MORGAN AND MORECAMBE OFFSHORE WIND FARMS: TRANSMISSION ASSETS

Applicants' Response to Deadline 5 submissions from Statutory Consultees and other organisations

Document Reference: S_D6_2
F01

22 October 2025

Figure 1.18a: Defended 1% AEP joint probability event plus 20% climate change uplift event

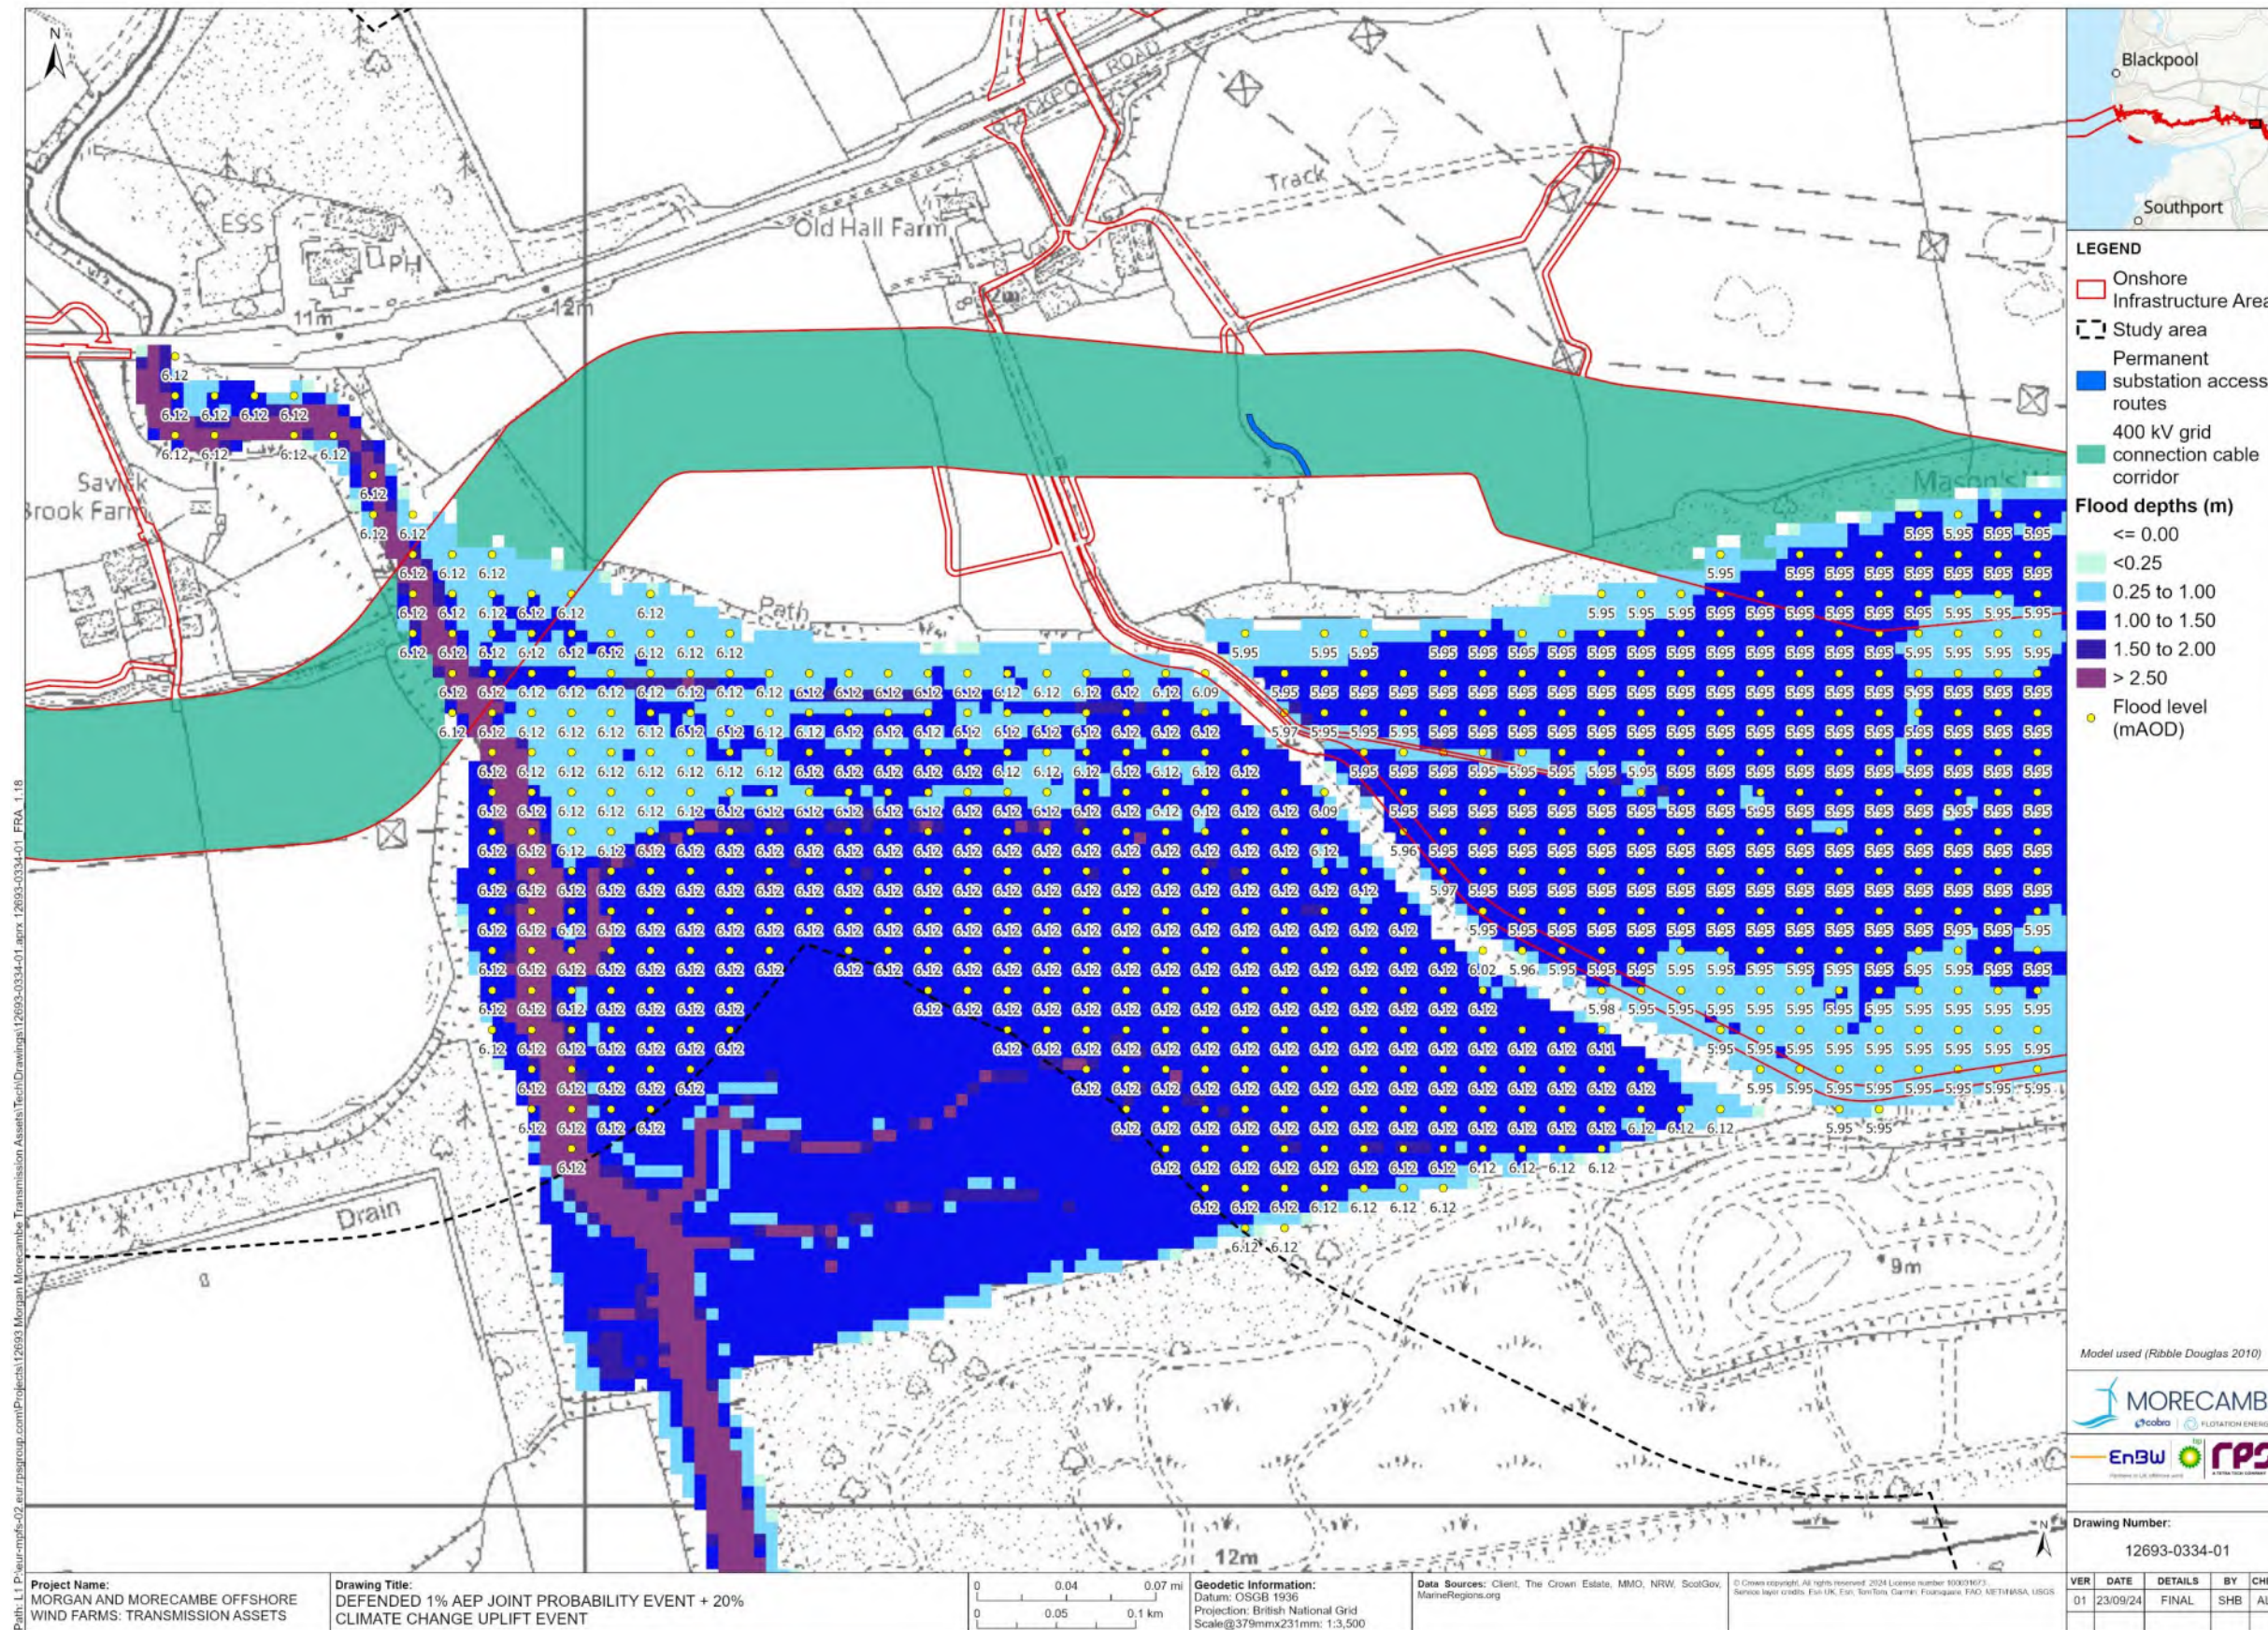
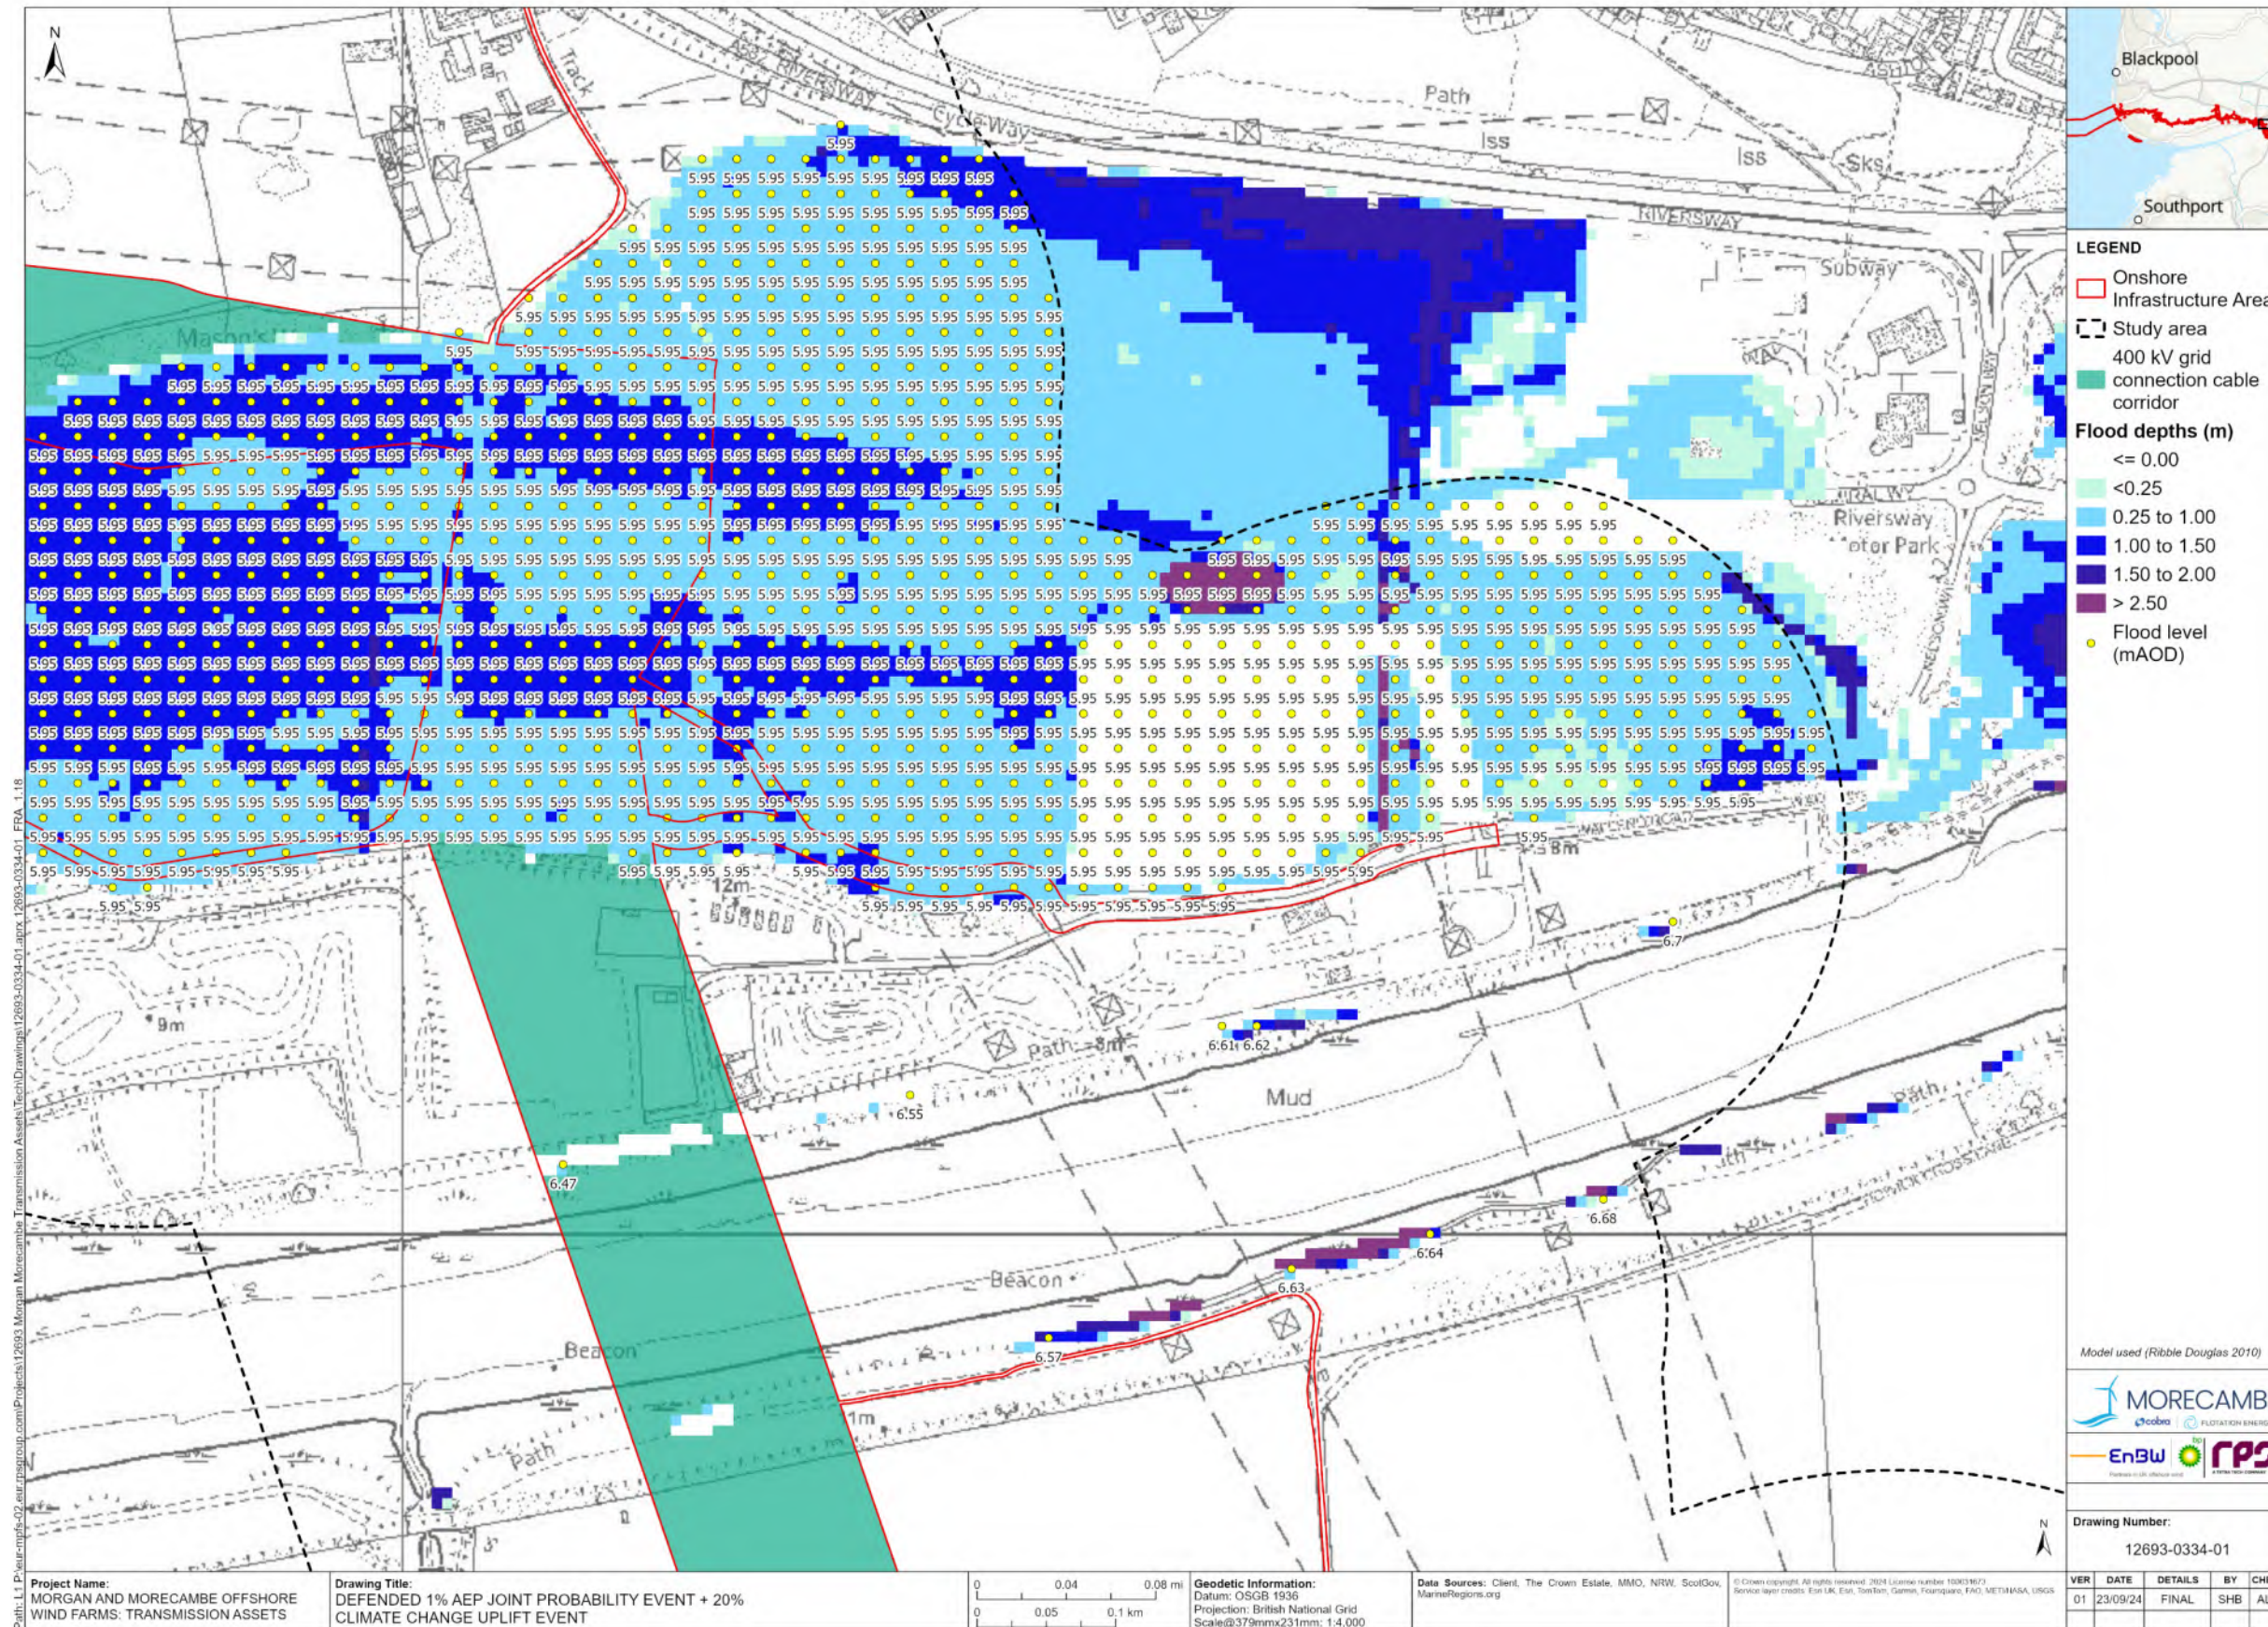
REP5-168	<p>Volume 3, Annex 2.3: Flood risk assessment - part 2</p>	<p>The Applicants note this comment and confirm that the discrepancy only appeared on the tracked version and therefore, no changes were required. The</p>

Reference	IP submission	Applicants' response
168.9	<p>Pages 163- 166</p> <p>Issue: Changing in titles and figure numbers appears to have resulted in a discrepancy between the new figure label in the report and the figure reference in the original title box of the drawing.</p> <p>Impact: This makes references somewhat problematic and confusing.</p> <p>Solution: Clerical error requiring correction</p>	<p>Applicants have ensured that all figure references and numbers are consistent. An updated version of volume 3, Annex 2.3: Flood risk assessment (F3.2.3/F03) has been submitted at Deadline 6.</p>
REP5-168 168.10	<p>Volume 3, Annex 2.3: Flood risk assessment part 3</p> <p>Issue: Like previous comments.</p> <p>Changing in titles and figure numbers appears to have resulted in a discrepancy between the new figure label in the report and the figure reference in the original title box of the drawing.</p> <p>e.g. Figure 1.23: Undefended 1% AEP fluvial event plus 20% climate change uplift on Page 199 is figure 1.17 in the drawing title box.</p> <p>Impact: This makes referencing somewhat problematic and confusing.</p> <p>Solution: Clerical error requiring correction</p>	<p>The Applicants note this comment and have updated all figure references and numbers where appropriate. An updated version of volume 3, Annex 2.3: Flood risk assessment (F3.2.3/F03) has been submitted at Deadline 6.</p>
